Architect
Reddy Architecture + Urbanism
Residential Development
Clonattin, Gorey

Title
Quality Audit
Sheet 1 OF 5

Dwg. No.
CLO-CSC-ZZ-XX-DR-C-0056

Architect	Reddy Architecture + Urbanism			
Project	Residential Development Clonattin, Gorey			
Title	Proposed Road Markings Sheet 1 OF 5			
Dwg. No.	CLO-CSC-ZZ-XX-DR-C-0021			
Date	Drn. by	Chkd. by	Apprd. by	Scale
May 2020	AB	GL	NB	1:500@A1
				Revision P4

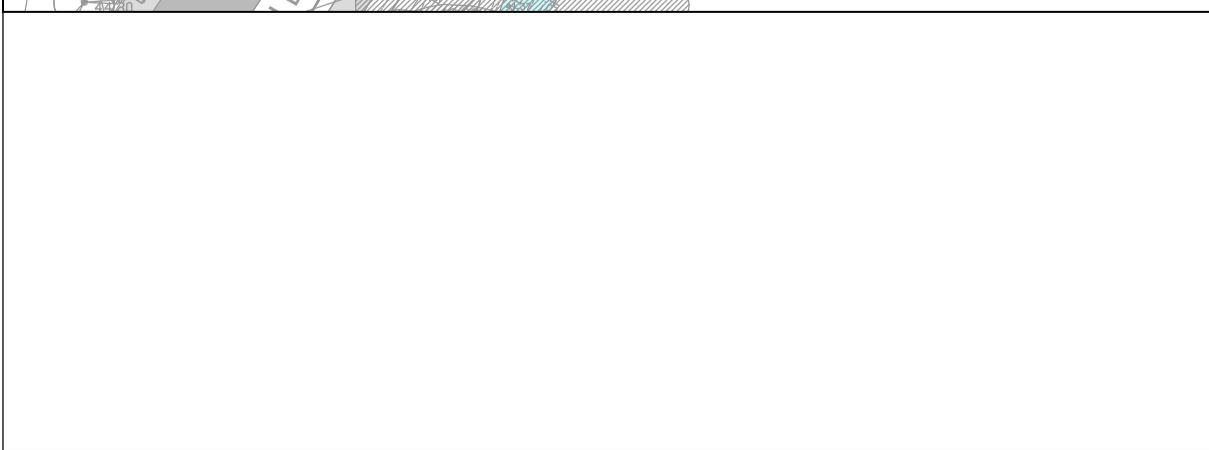
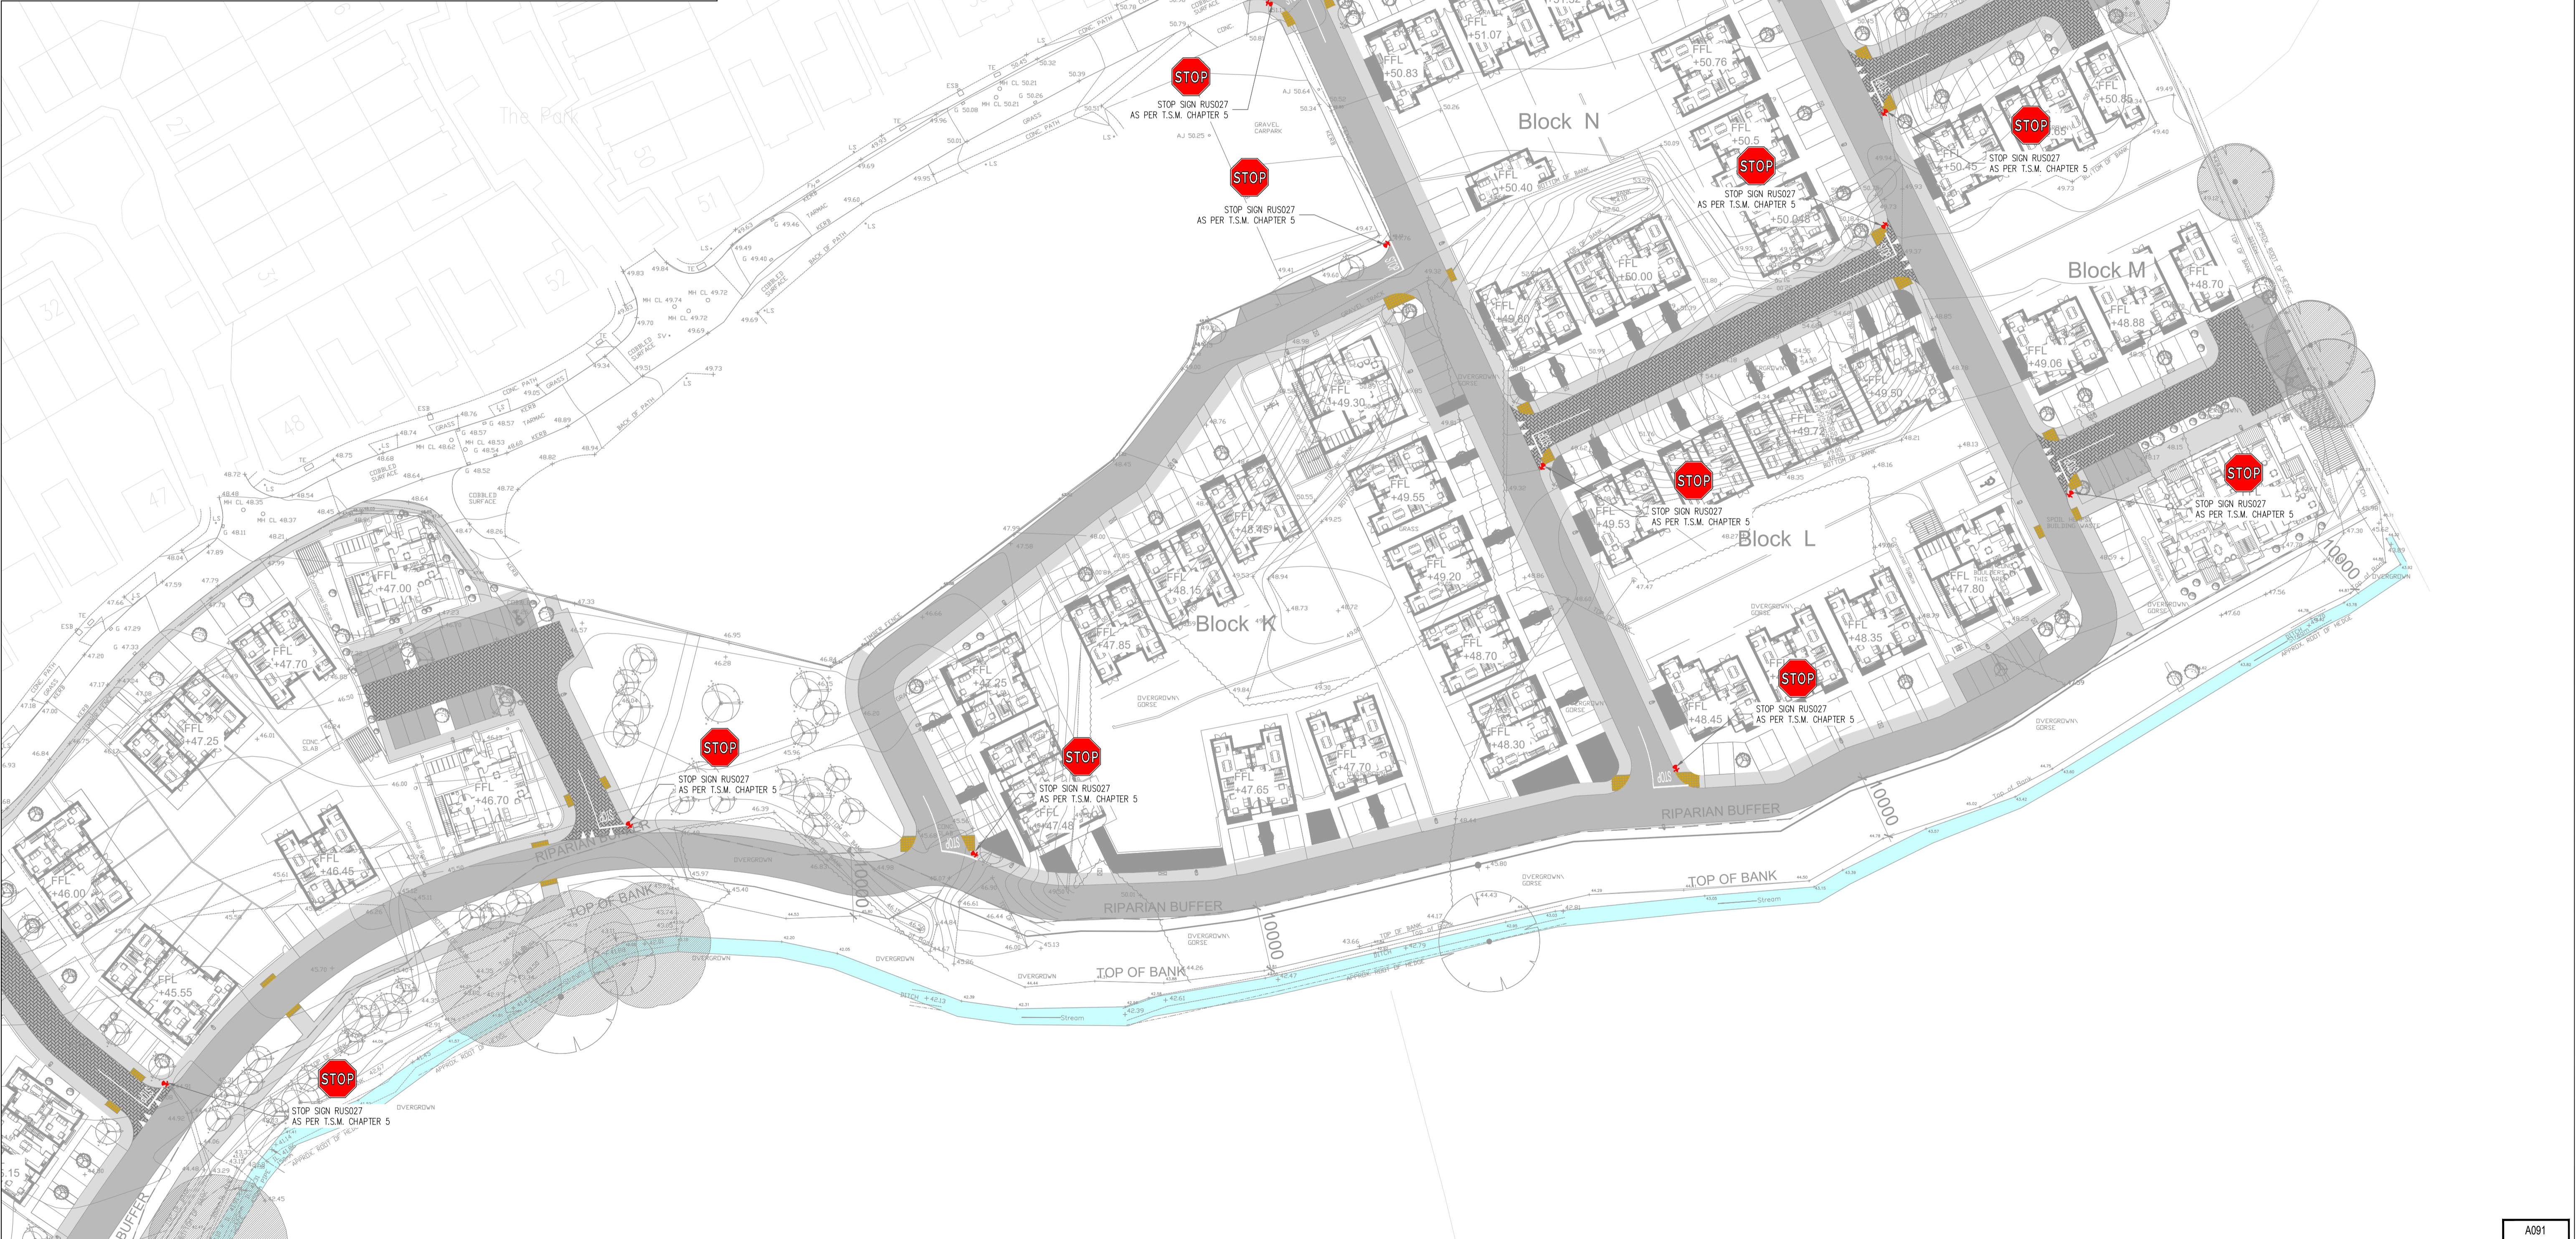
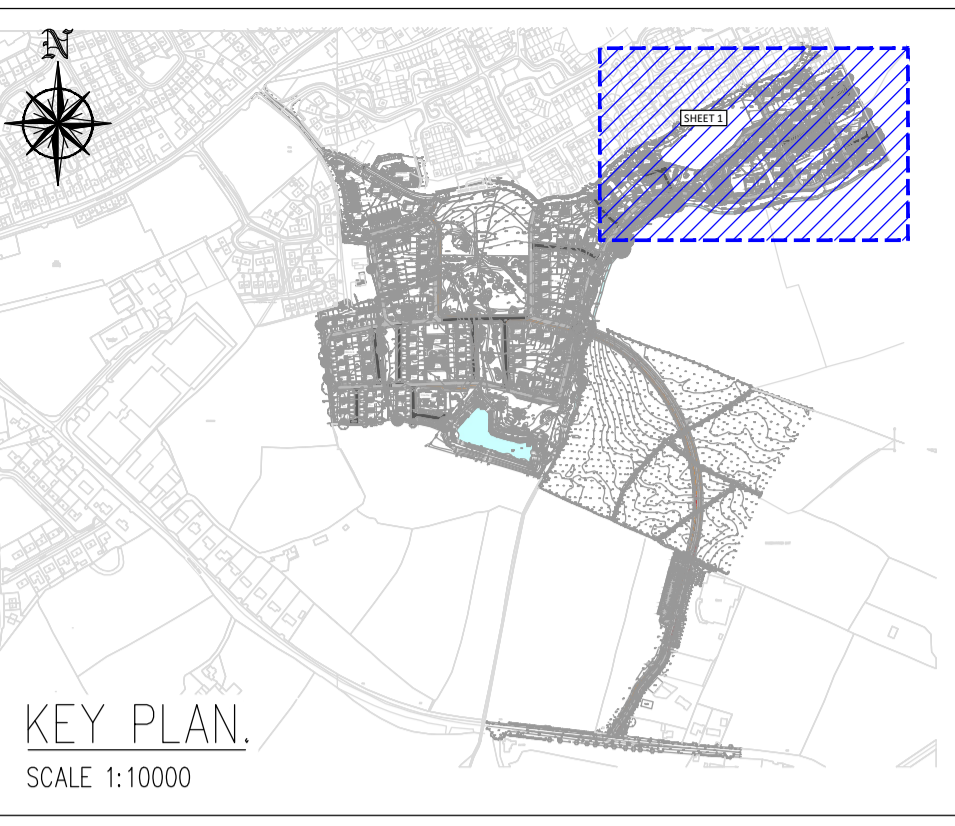
(QA - 4.10)
IN RESPONSE TO ITEM 4.10 OF THE QUALITY AUDIT,
ALL JUNCTIONS CHANGED FROM YIELD TO STOP SIGNS & ROAD MARKINGS.

Architect	Reddy Architecture + Urbanism
Project	Residential Development Clonattin, Gorey
Title	Proposed Visibility Splay
Dwg. No.	CLO-CSC-ZZ-XX-DR-C-0026
Date	May 2020
Dm by	AB
Chkd by	GL
Apprd by	NB
Scale	AS SHOWN
Revision	<b>P4</b>

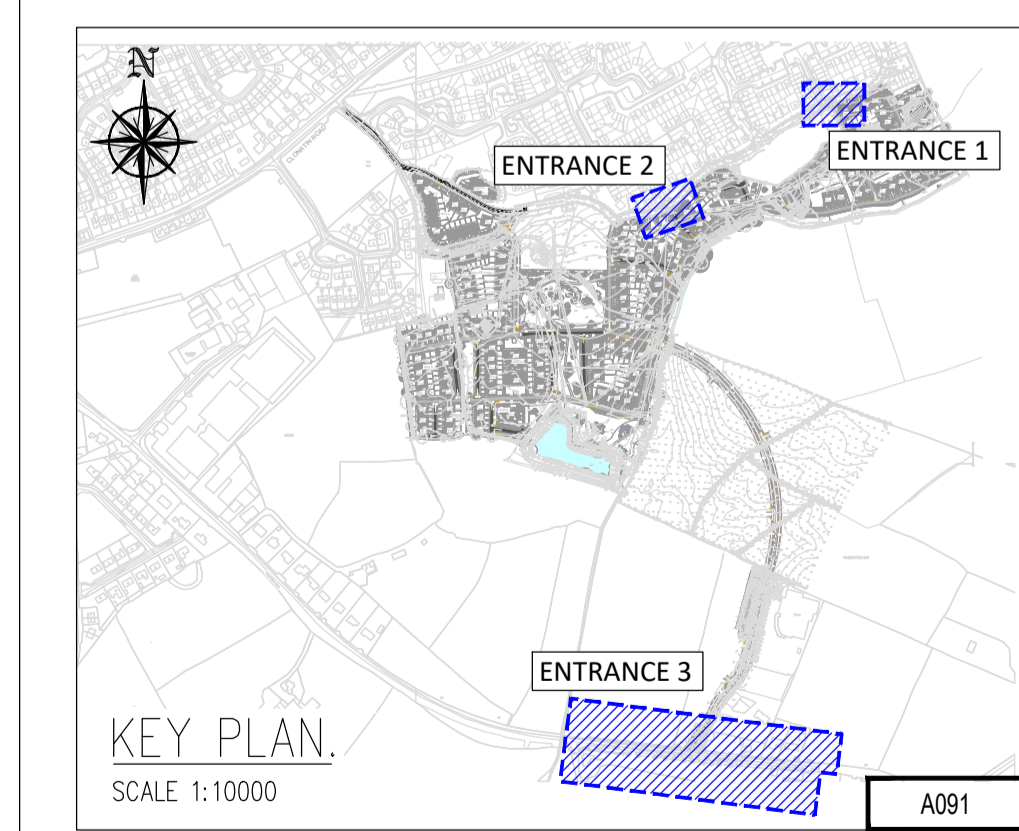
(QA - 4.8)
IN RESPONSE TO ITEM 4.8 OF THE QUALITY AUDIT,
TREES REMOVED TO COMPLY WITH VISIBILITY SPLAY

Architect	Reddy Architecture + Urbanism			
Project	Residential Development Clonattin, Gorey			
Title	Quality Audit Sheet 5 OF 5			
Dwg. No.	CLO-CSC-ZZ-XX-DR-C-0060			
Date	Drn by	Chkd by	Apprd by	Scale
May 2020	AB	GL	NB	1:500@A1

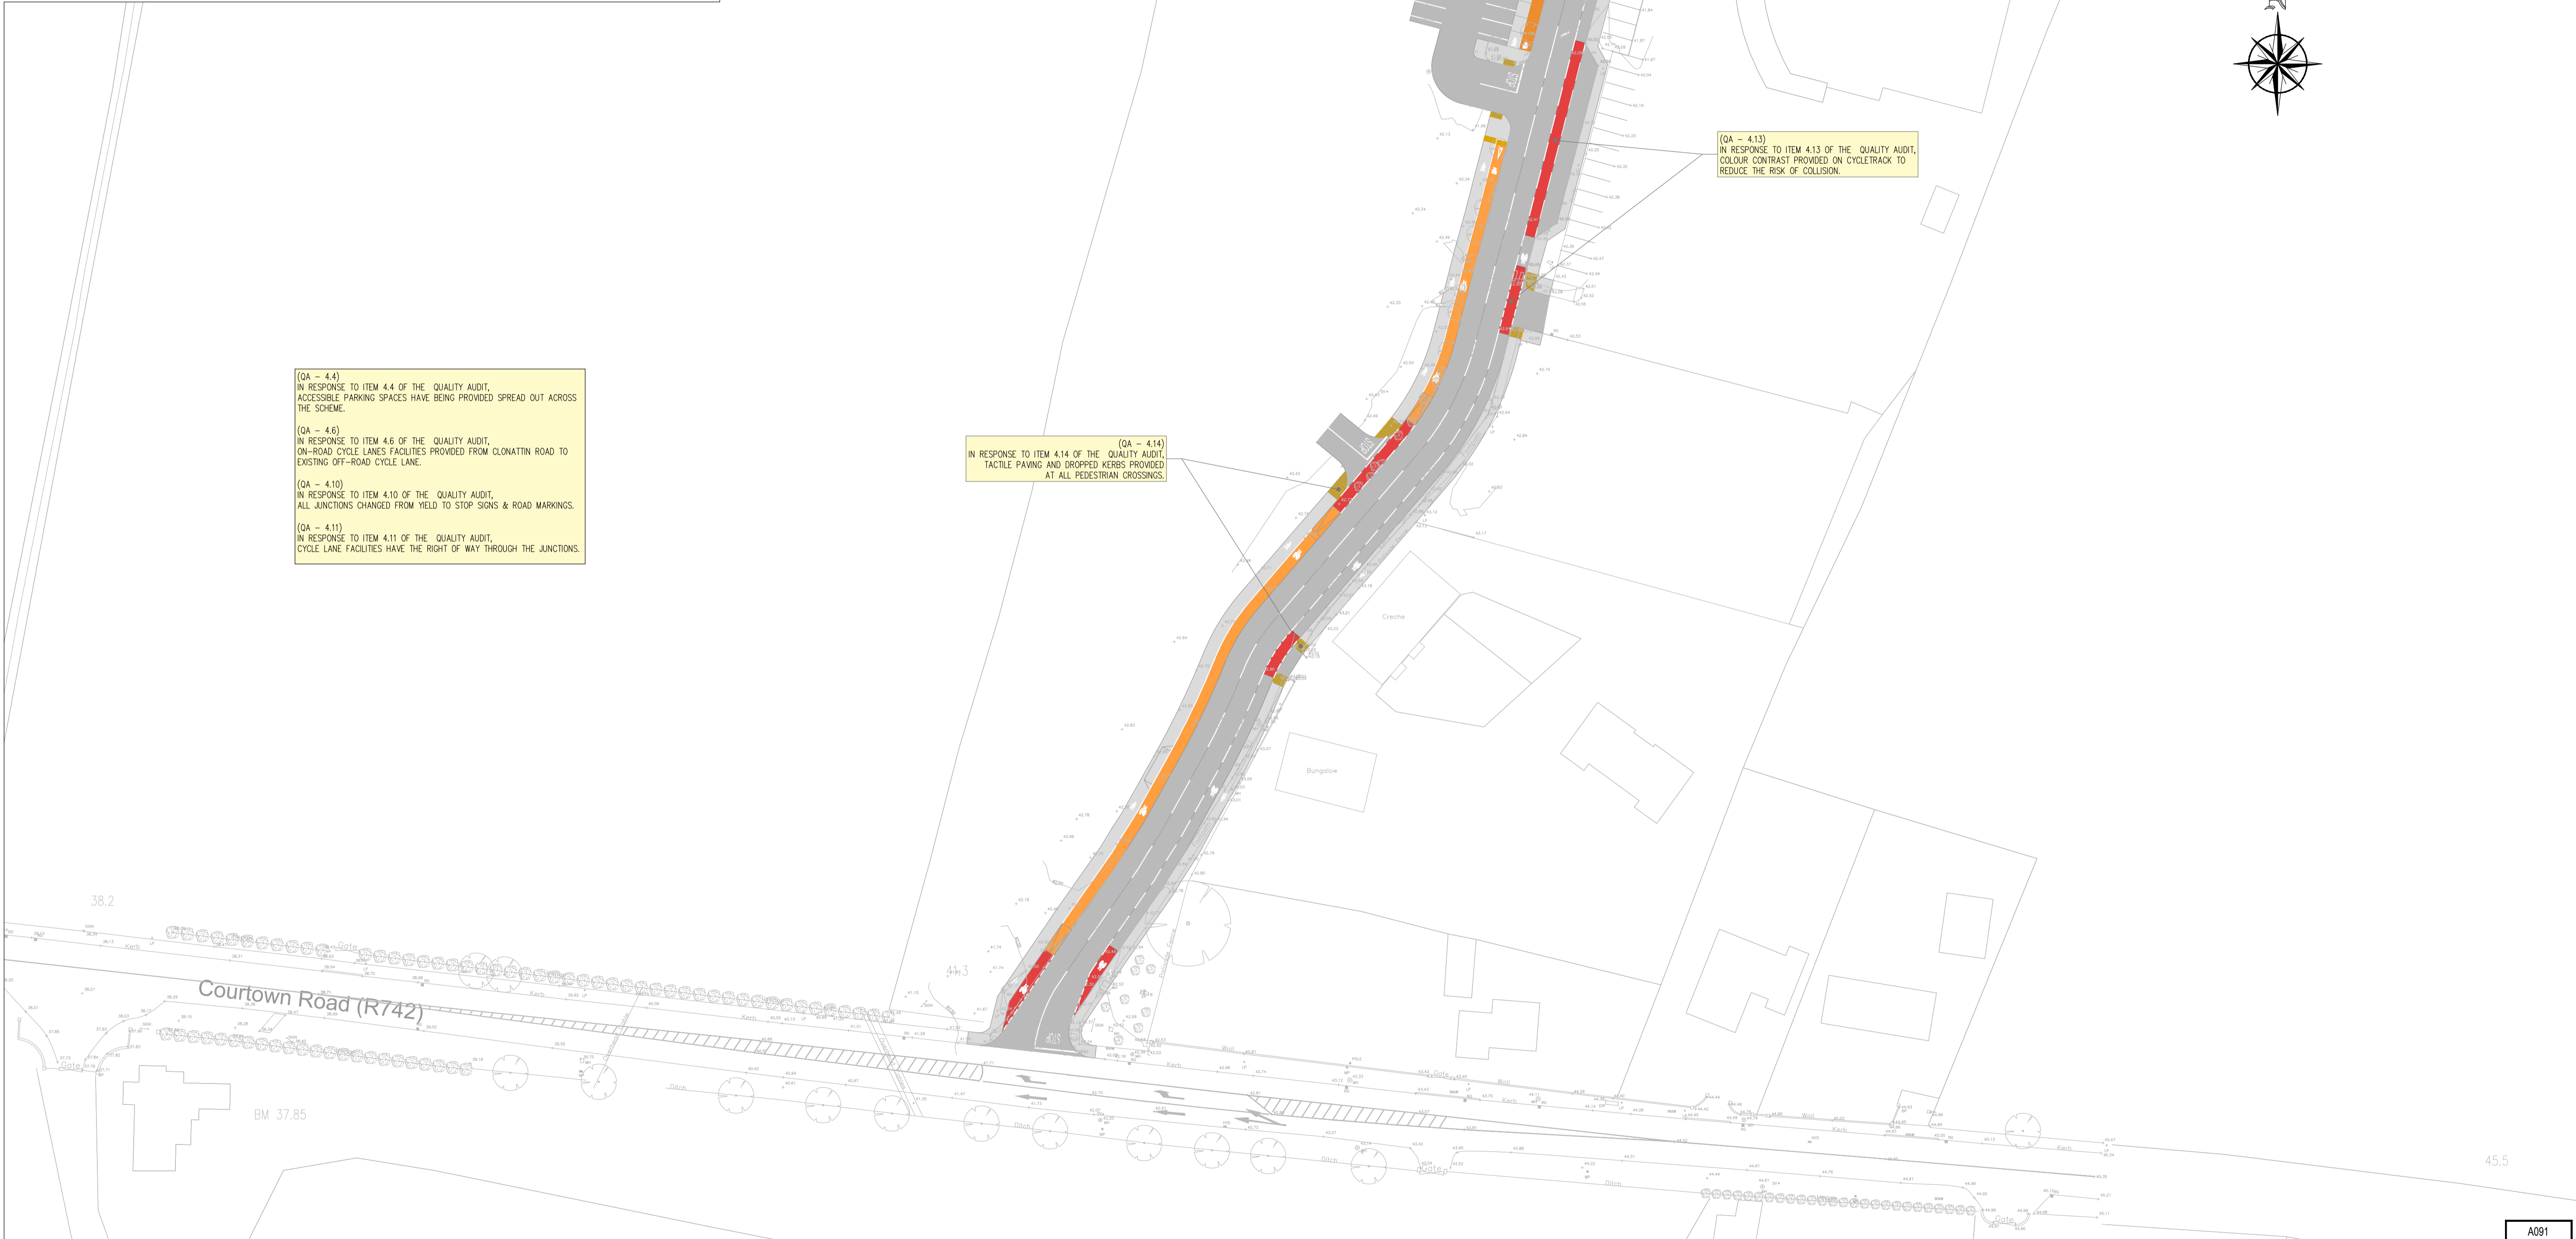
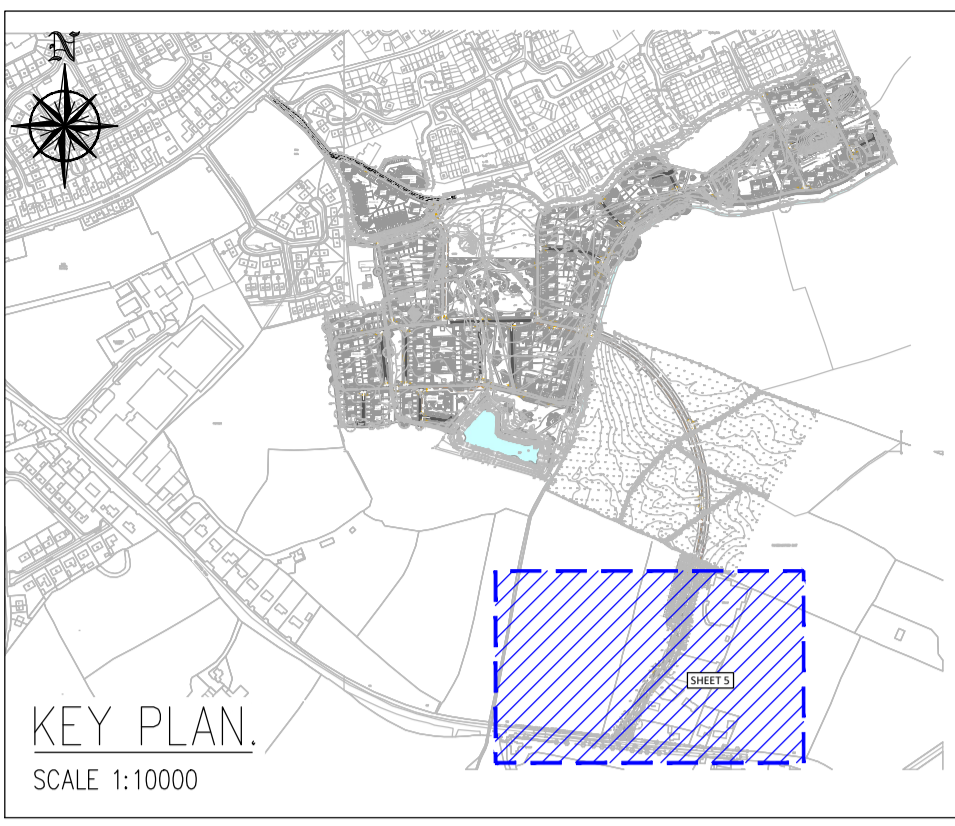
(QA - 4.1 & 4.3)
IN RESPONSE TO ITEM 4.1 & 4.3 OF THE QUALITY AUDIT,
ADEQUATE CROSSING FACILITIES PROVIDED AT ALL ROADS
JUNCTIONS.

(QA - 4.4)
IN RESPONSE TO ITEM 4.4 OF THE QUALITY AUDIT,
ACCESSIBLE PARKING SPACES HAVE BEEN PROVIDED SPREAD OUT
ACROSS THE SCHEME.

(QA - 4.6)
IN RESPONSE TO ITEM 4.6 OF THE QUALITY AUDIT,
ON-ROAD CYCLE LANES FACILITIES PROVIDED FROM CLONATTIN ROAD TO
EXISTING OFF-ROAD CYCLE LANE.
